Subject: 125 Bayford Road Littlehampton BN17 5HW - LU/131/21/DOC

Planning Application Reference: LU/131/21/DOC

Proposal: Approval of details reserved by condition imposed under ref LU/13/21/PL relating to Condition Nos 3 - covered & secure cycle parking and 4 - electric vehicle charging space.

Proposed Site Plan plan 1:100

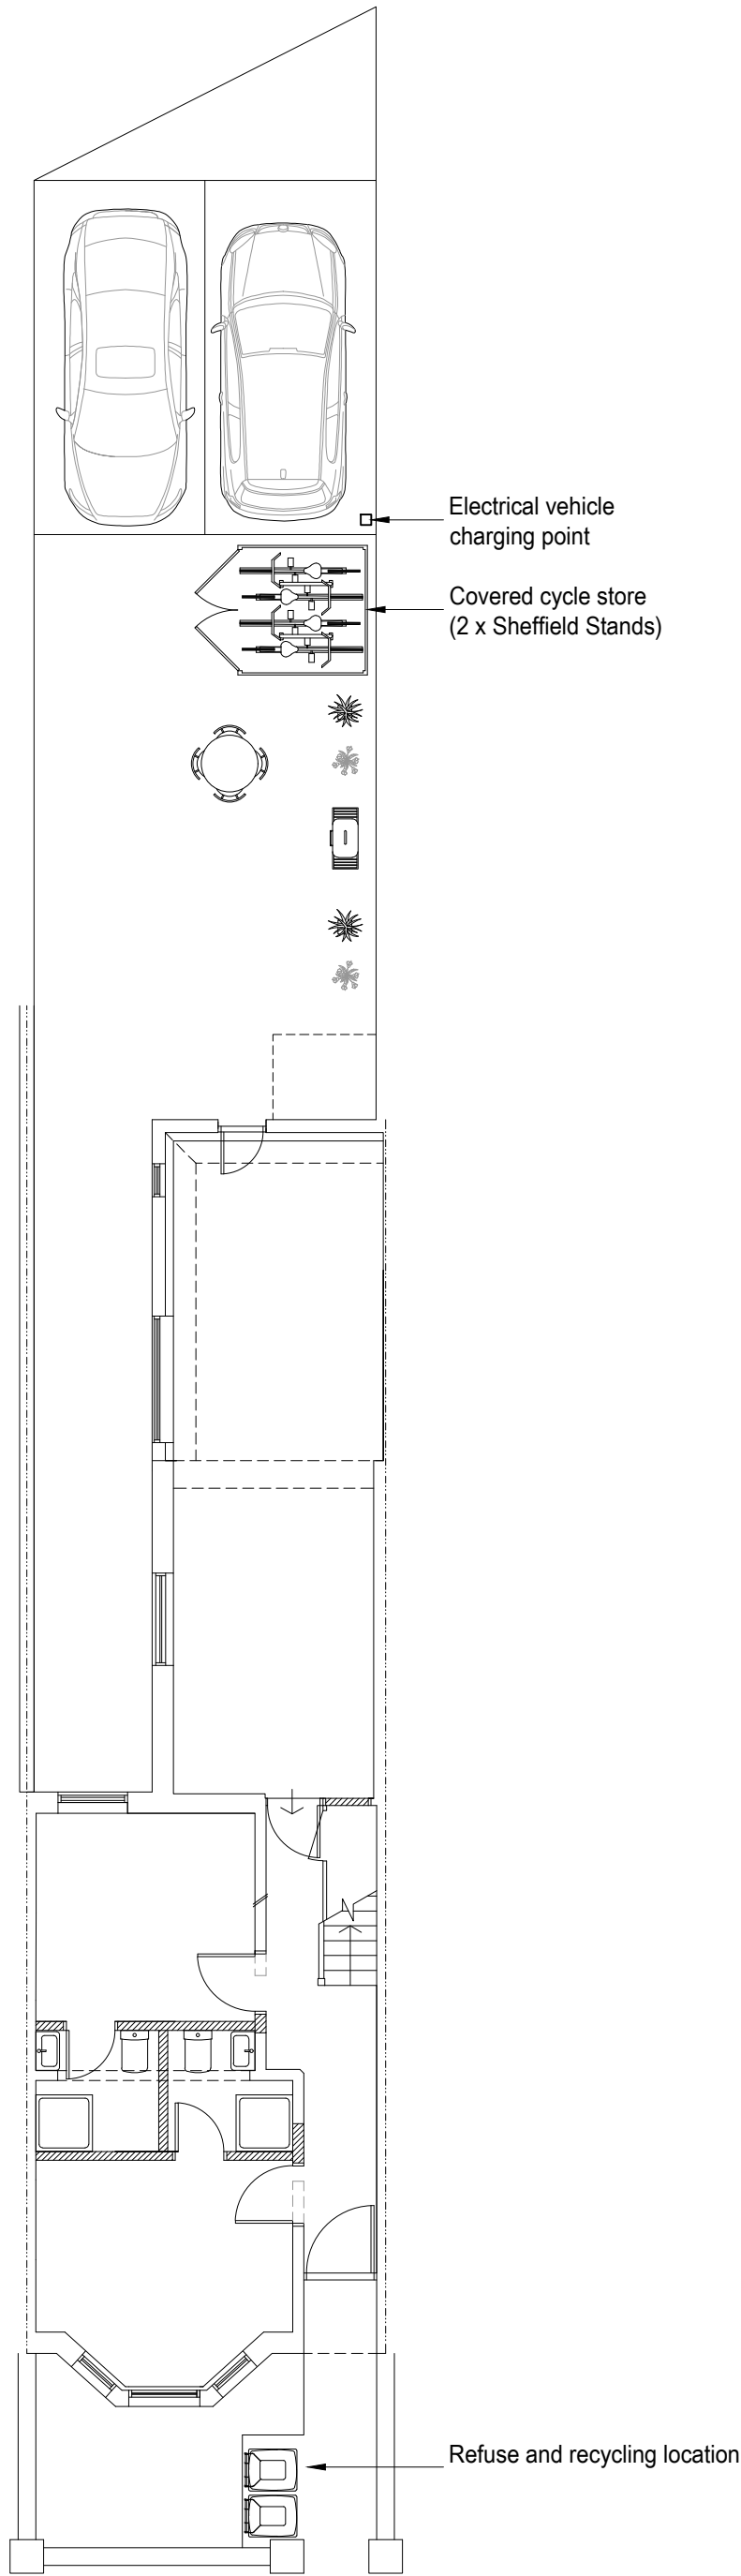
Having reviewed the document entitled 'Proposed site plan and cycle storage Dwg No 2445-01' I can confirm the plan confirms the location of an electric vehicle charging point. Further information is required to include details of the proposed Electric Vehicle Charging point. The information should include technical specification from the manufacturer confirming that the charge point power output is 7kW in accordance with government guidance document 'Electric Vehicle Charging in Residential and Non-Residential Buildings' (July 2019) [produced by DfT], available from: [Electric vehicle charging in residential and non-residential buildings \(publishing.service.gov.uk\)](https://www.publishing.service.gov.uk/government/uploads/system/uploads/attachment_data/file/824442/electric_vehicle_charging_in_residential_and_non-residential_buildings.pdf)
